WEST SUSSEX COUNTY COUNCIL CONSULTATION

TO:	Arun District Council FAO: Maria Tomalova
FROM:	WSCC - Highways Authority
DATE:	5 June 2020
LOCATION:	8 Longford Road Bognor Regis PO21 1AQ
SUBJECT:	BR/110/20/PD Notification for Prior Approval under Schedule 2, Part 3, Class M for the change of use from a shop (A1 shops) to 1 No dwelling (C3 Dwelling house).
DATE OF SITE VISIT:	n/a
RECOMMENDATION:	Advice
S106 CONTRIBUTION TOTAL:	n/a

Proposed Ground Floor Plan
Scale: 1:50

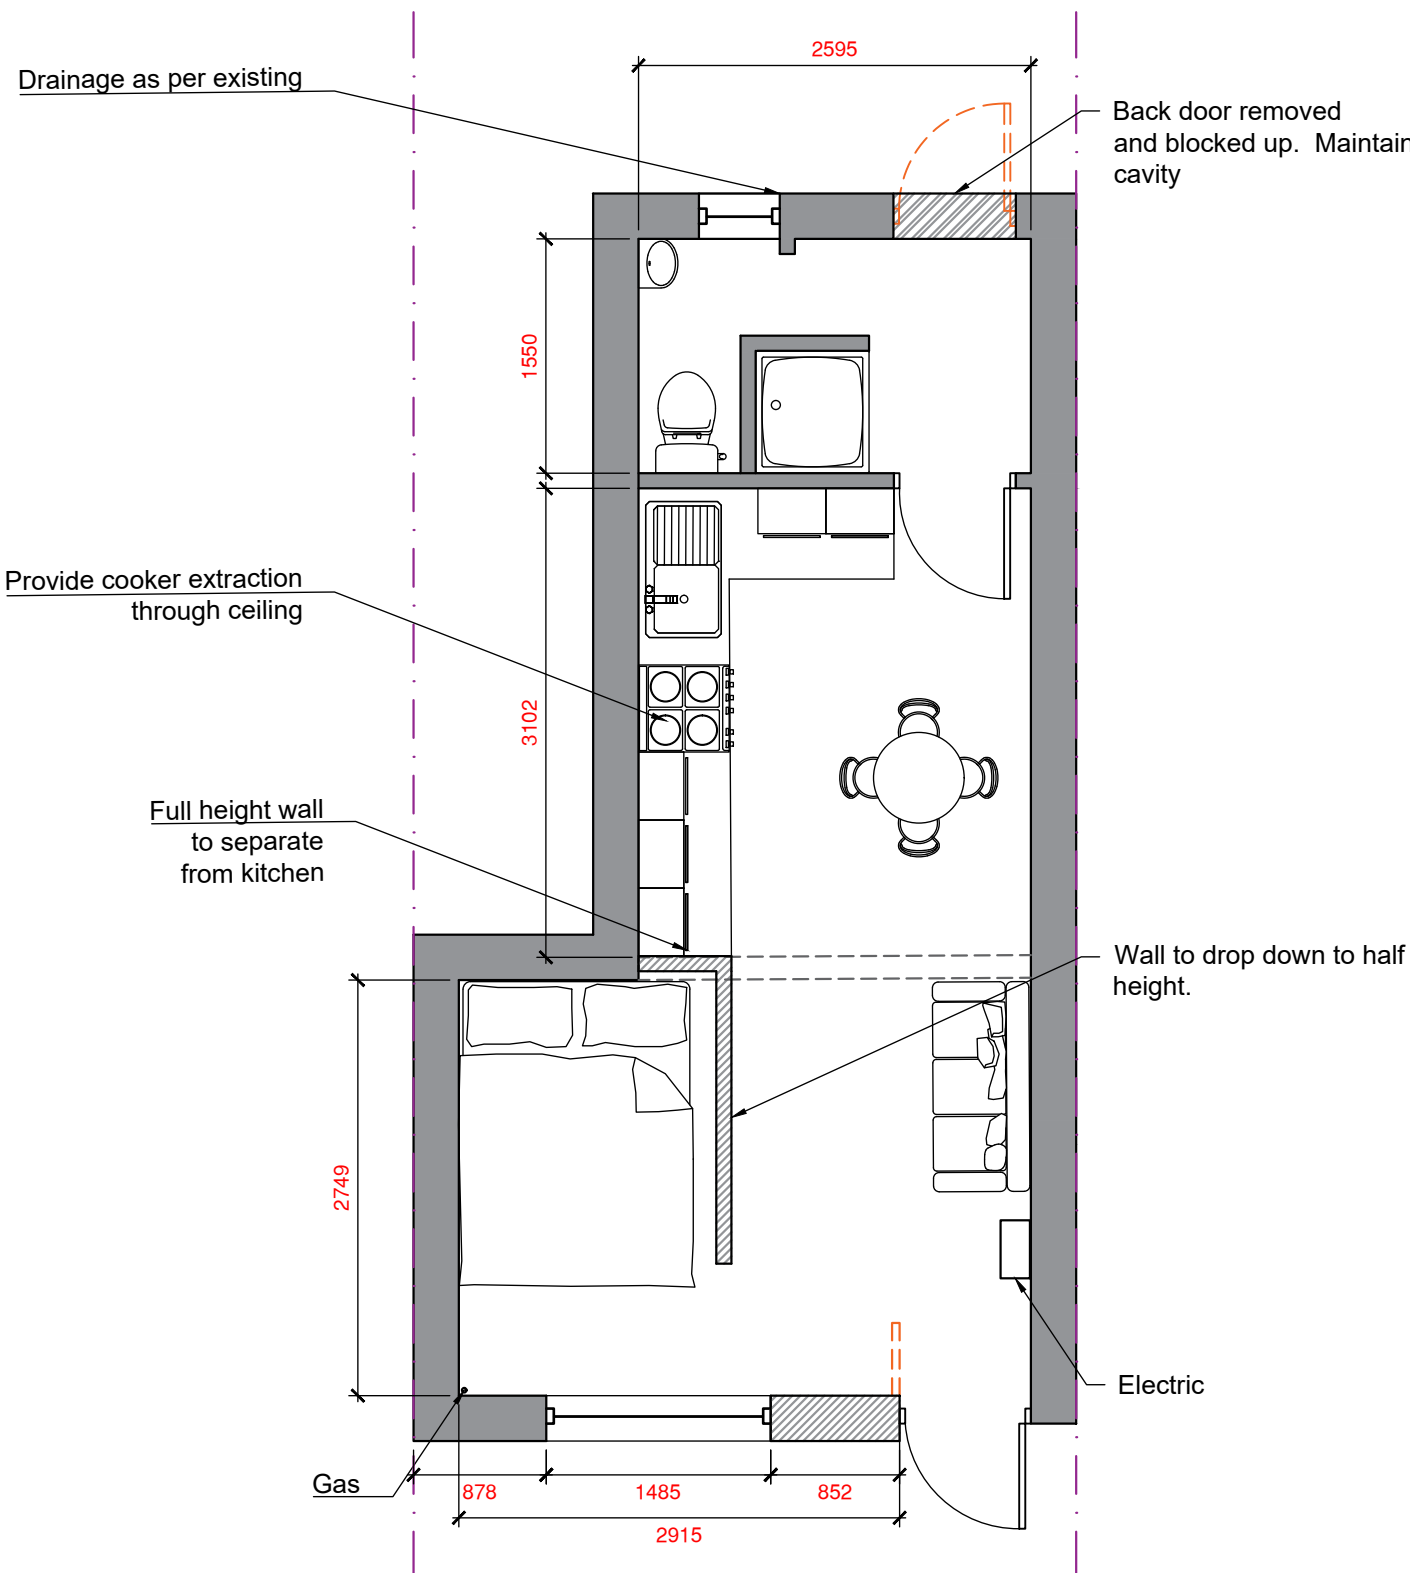
The applicant proposes a NIL parking provision due to the substandard parking area (3.7 x 4 metres) as seen on WSCC Local Mapping. This considered, the LHA appreciate the sustainable location of the site, situated within close proximity to local shops, bus services and a train station, and consider that there are viable options for sustainable modes of transport to reduce the reliance upon the private car. Furthermore, the LHA anticipate that the level of traffic generated by this proposal would not result in an increase over the potential traffic generated through the retail use.

If the Local Planning Authority is minded to approve the application, they may wish to condition cycle parking.
